CITY OF ALBUQUERQUE

Re: Cielito Lindo
5109 Central
Traffic Circulation Layout
Architect's Stamp XX-XX-XX (K11-D085)

Based upon the information provided in your submittal received 11-18-16, the above referenced plan cannot be approved for Building Permit until the following comments are addressed:

A1.2

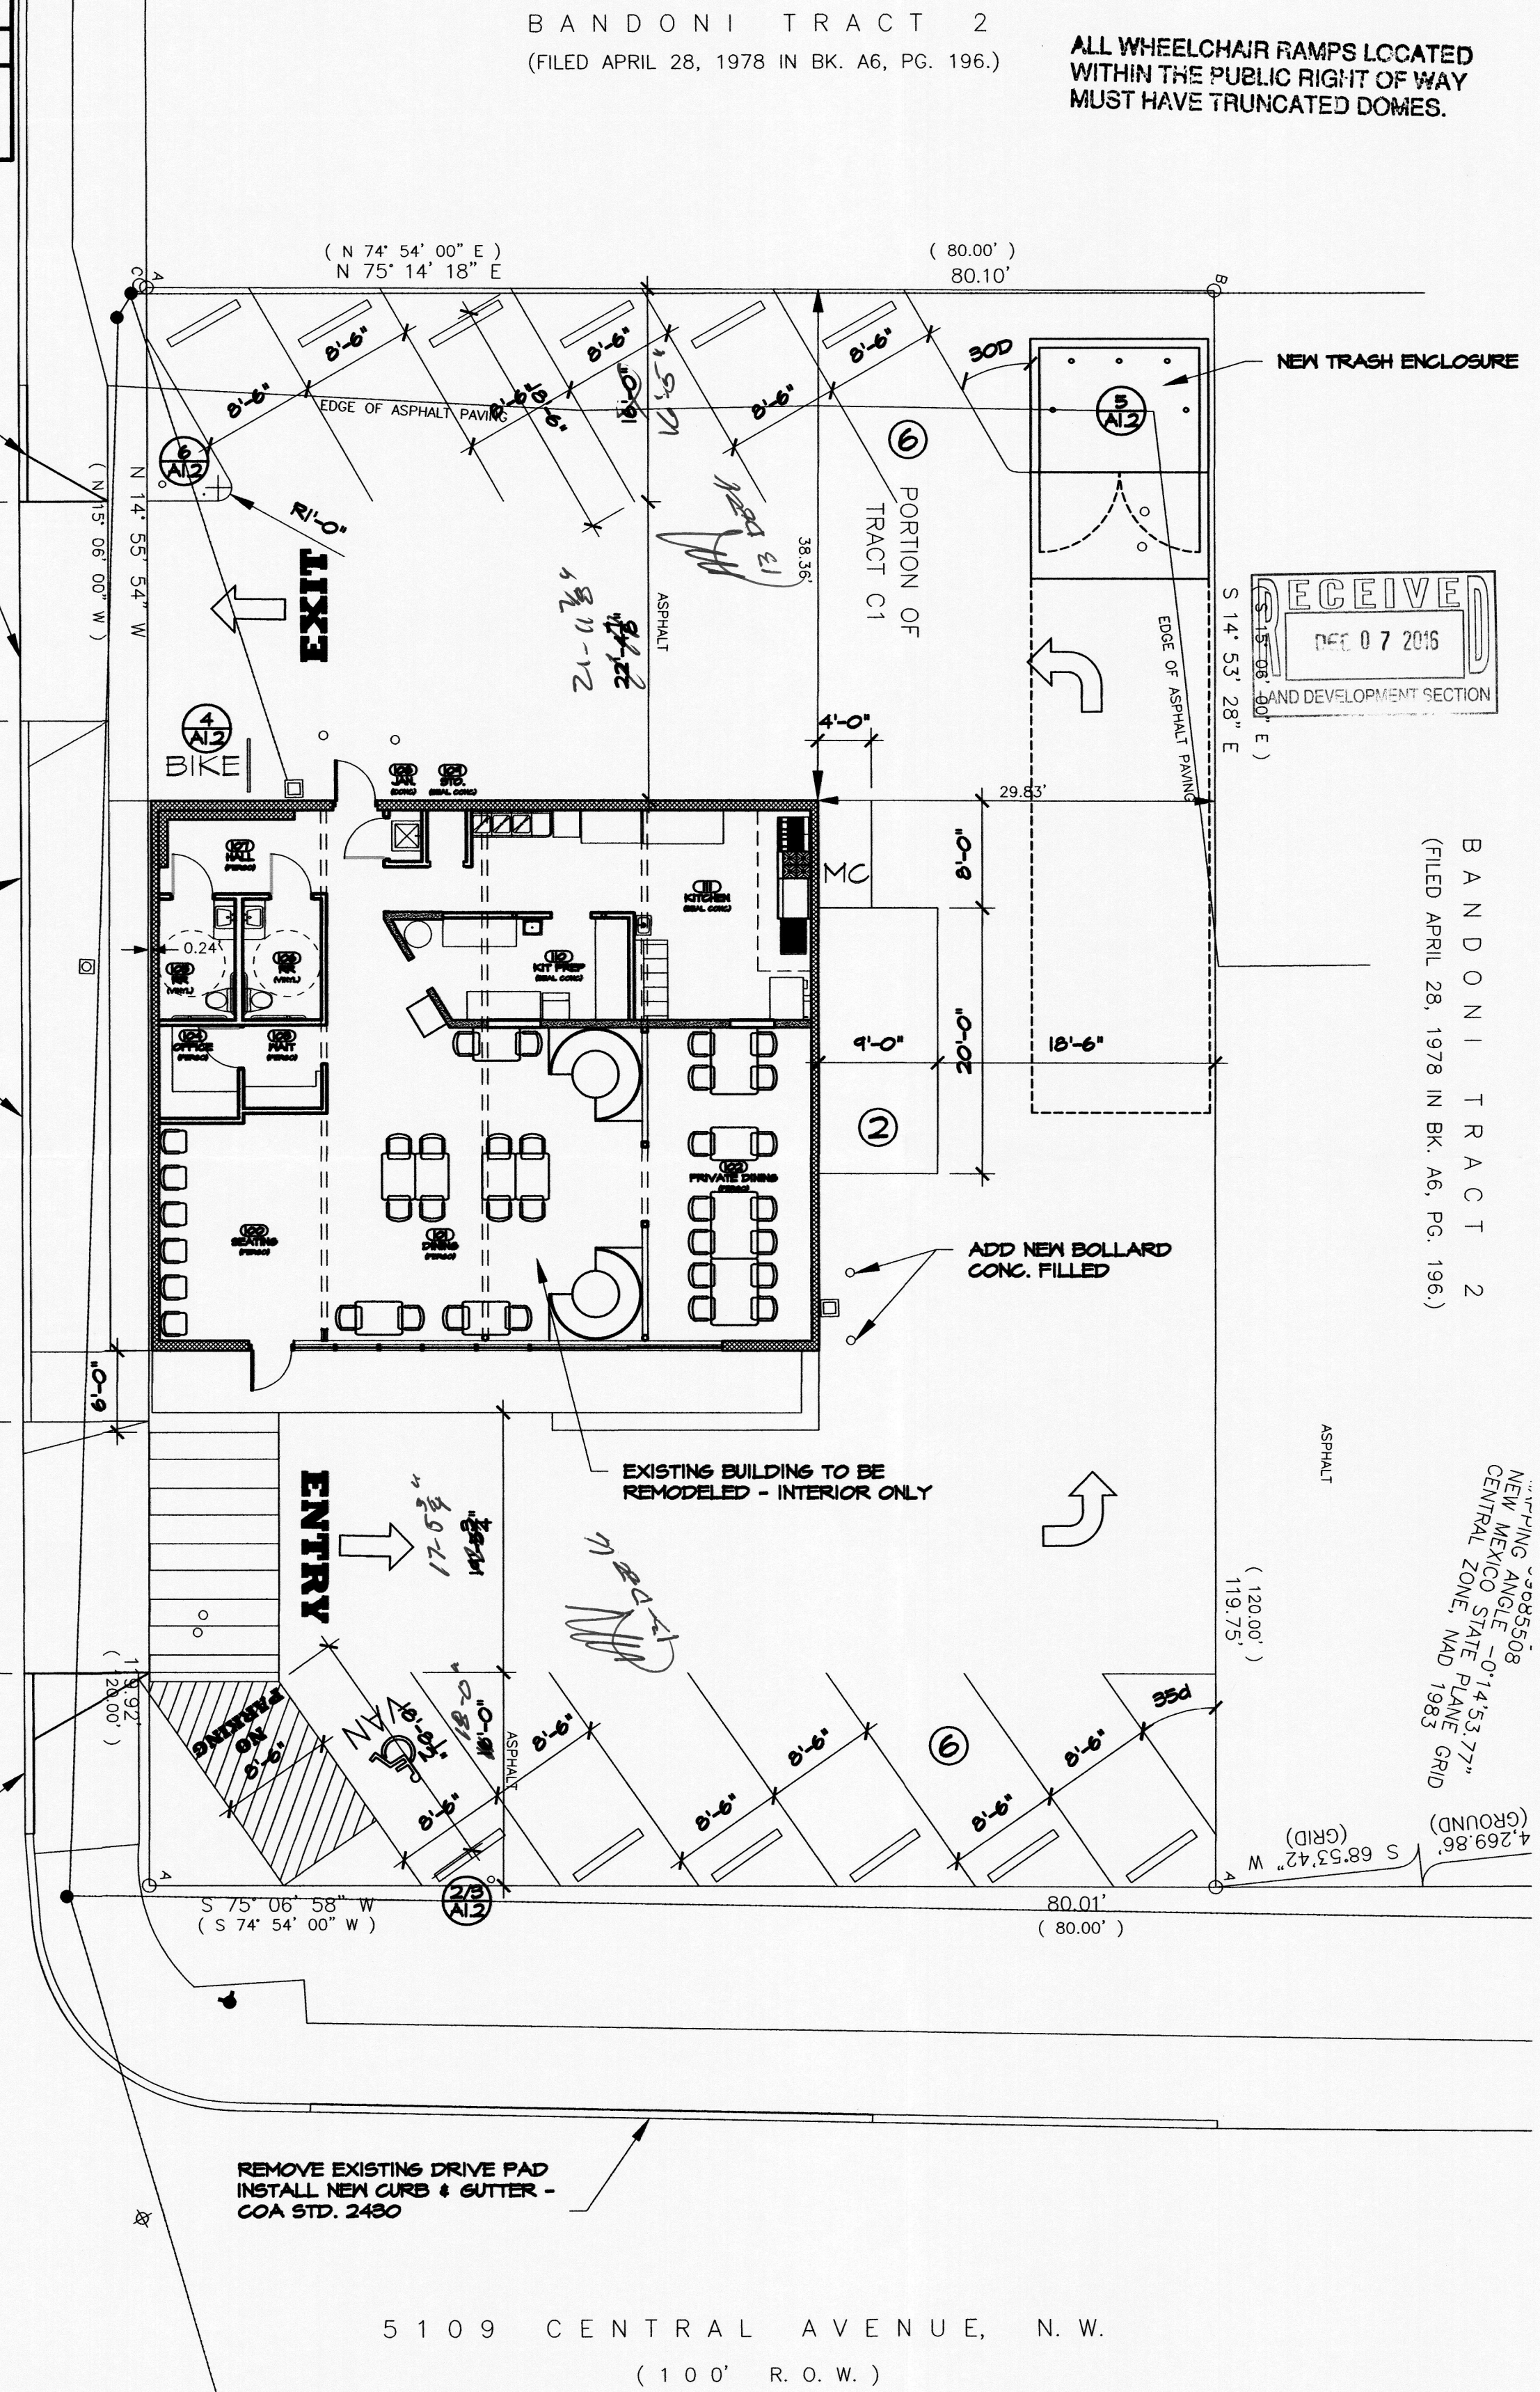
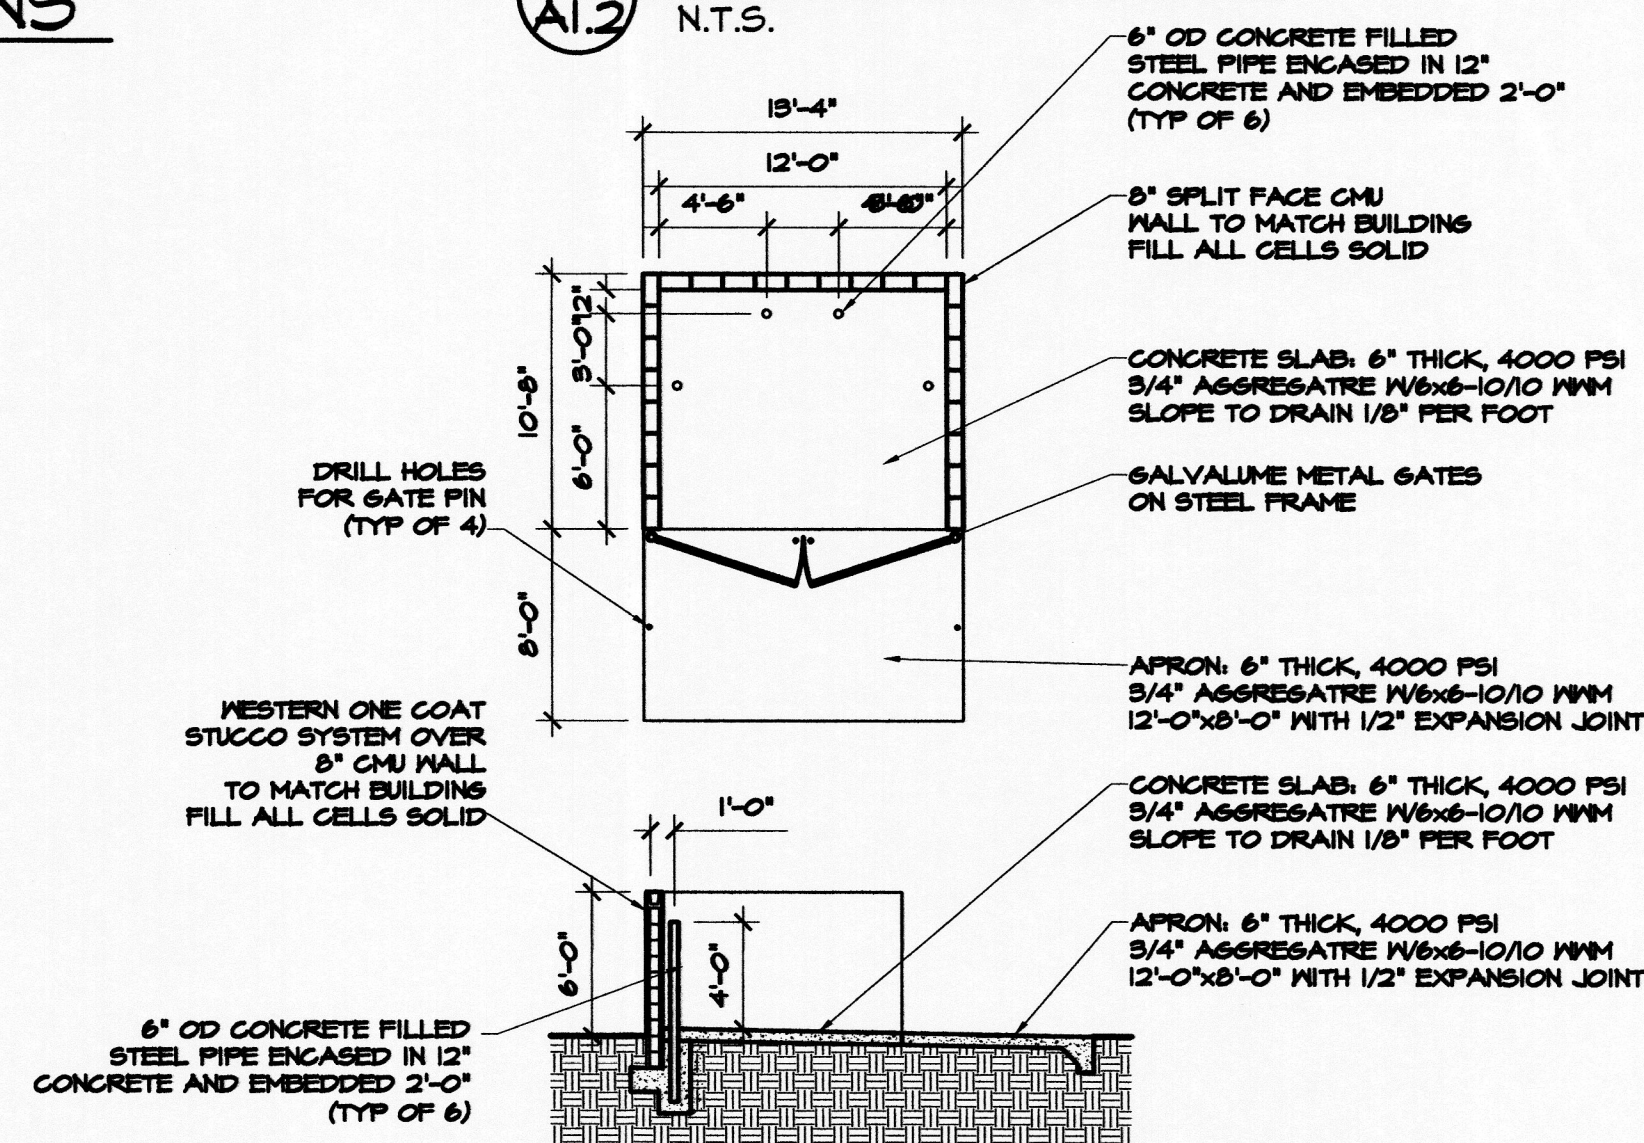
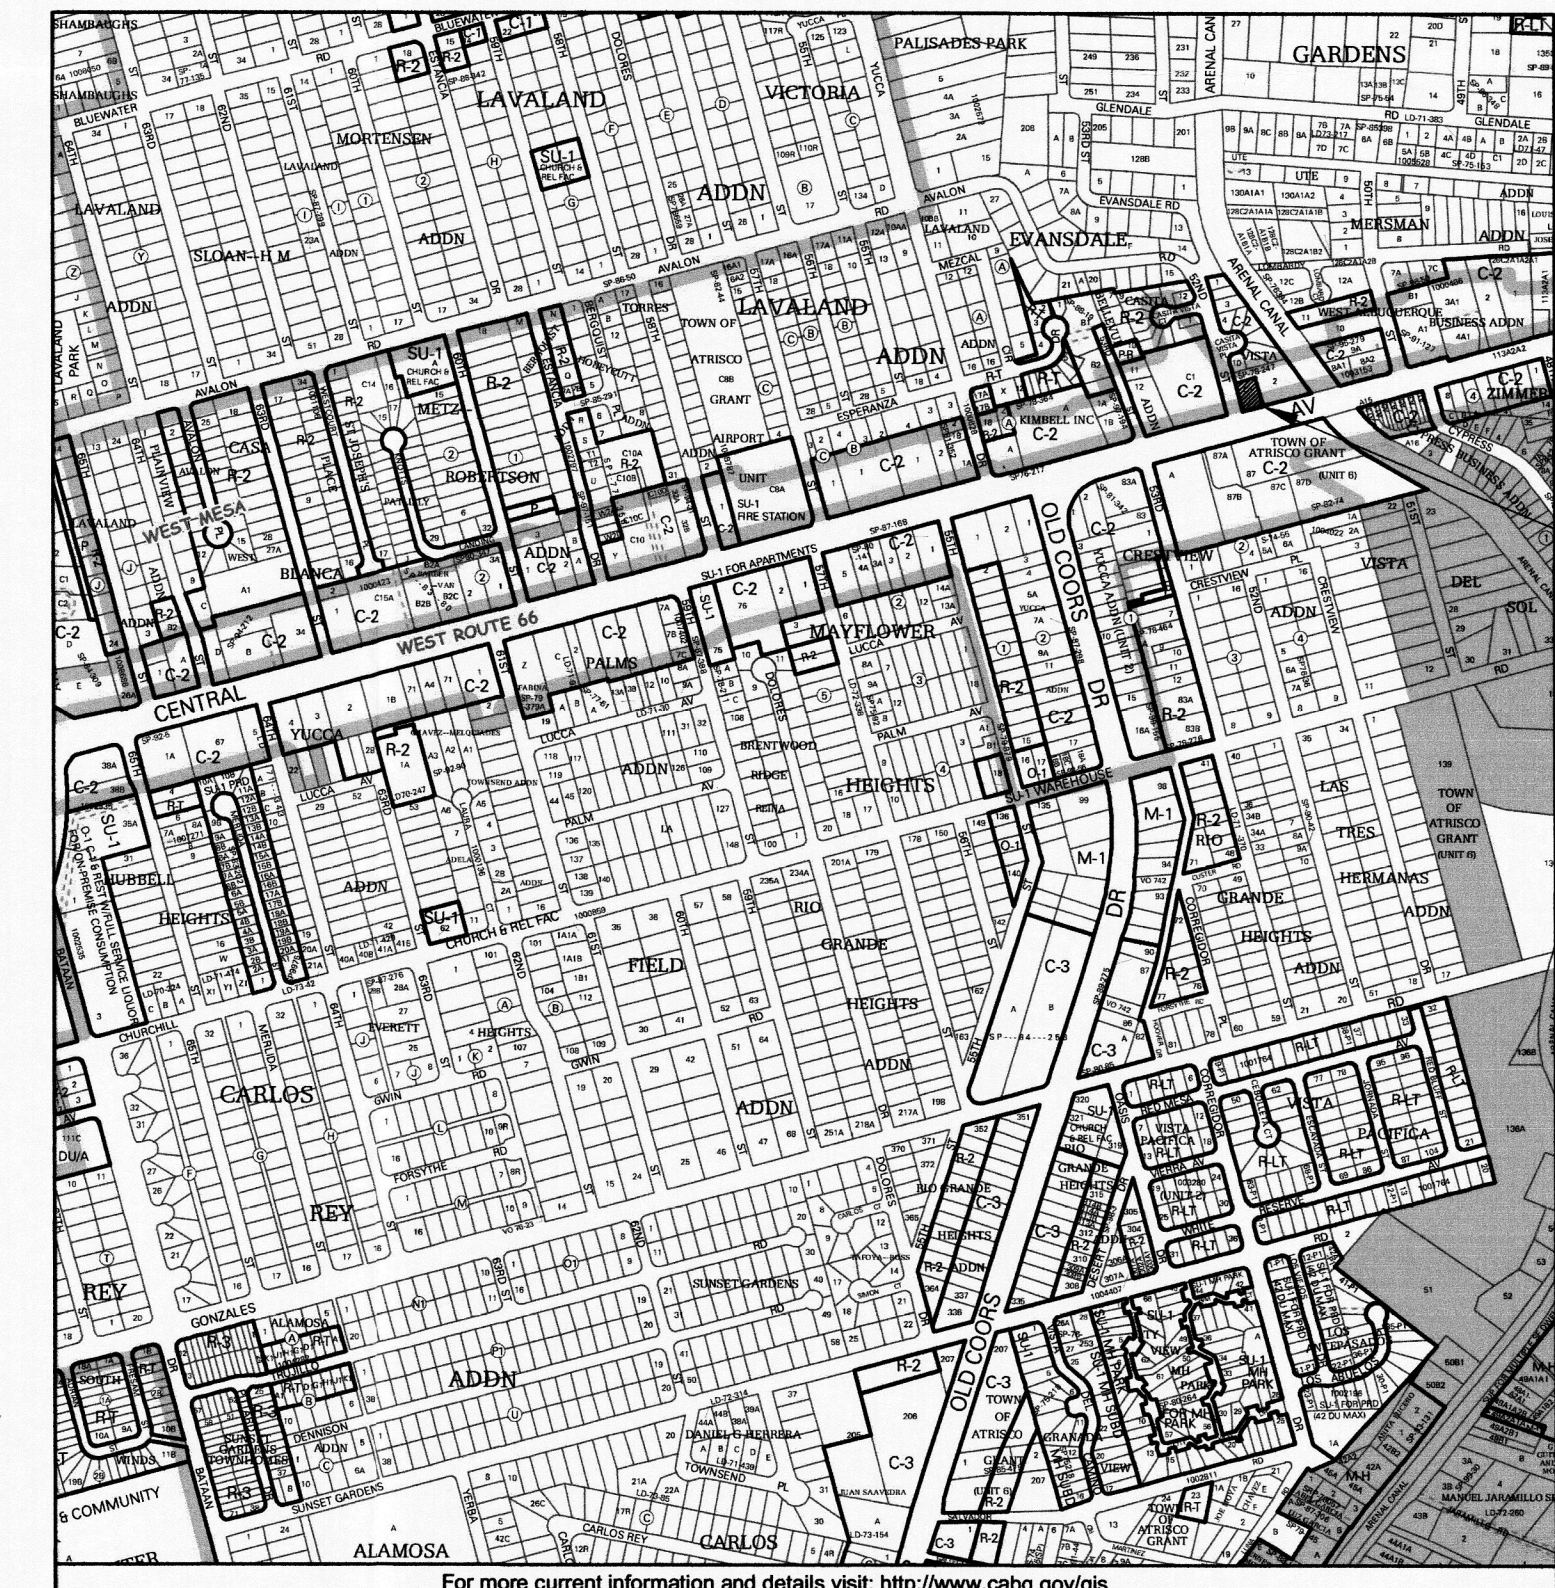
5. Dimension the drive aisle widths to the bollards.
6. Show the angle of the parking stalls. See Chapter 23, Section 7 of the City of Albuquerque *Development Process Manual*, for parking stall layout dimensions.

7. Per the zoning code, a 6 ft. wide ADA accessible pedestrian pathway is required from the public sidewalk to the building entrances. Please clearly show this pathway and provide details.

8. Please clarify the building frontage. Will there be a step added?
9. Refuse vehicle maneuvering should follow the vehicular path.
10. One-way vehicular paths require pavement directional signage and a posted **"Do Not Enter"** sign at the point of egress. Please show detail and location of posted signs.
